SM ROCHA, LLC

August 18, 2026

**RE: Flying Horse North Filing 8 / Transportation Memorandum
El Paso County, Colorado
SF2531**

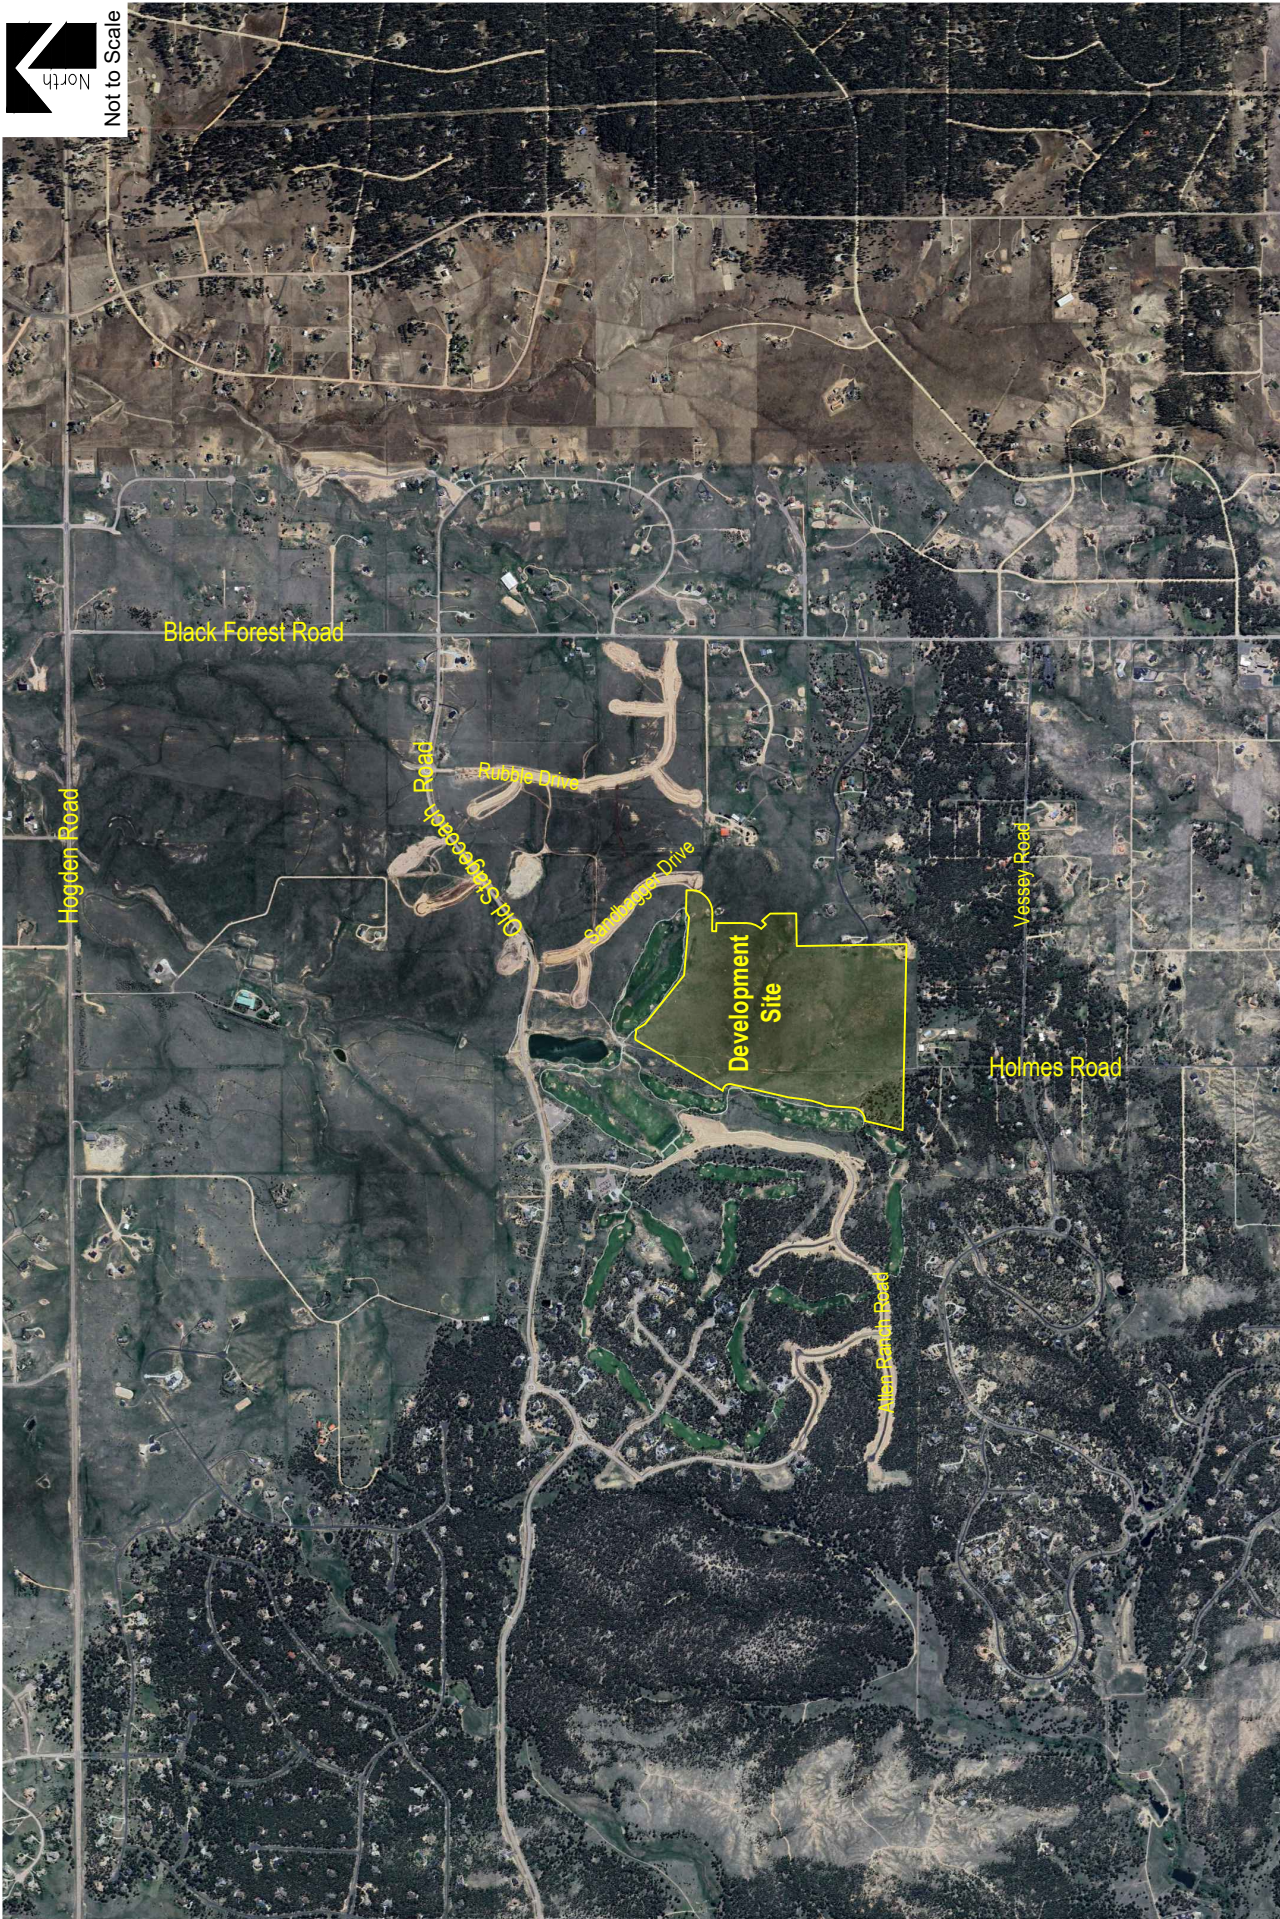
Please refer to the overall site plan for intersection sight distance requirements.
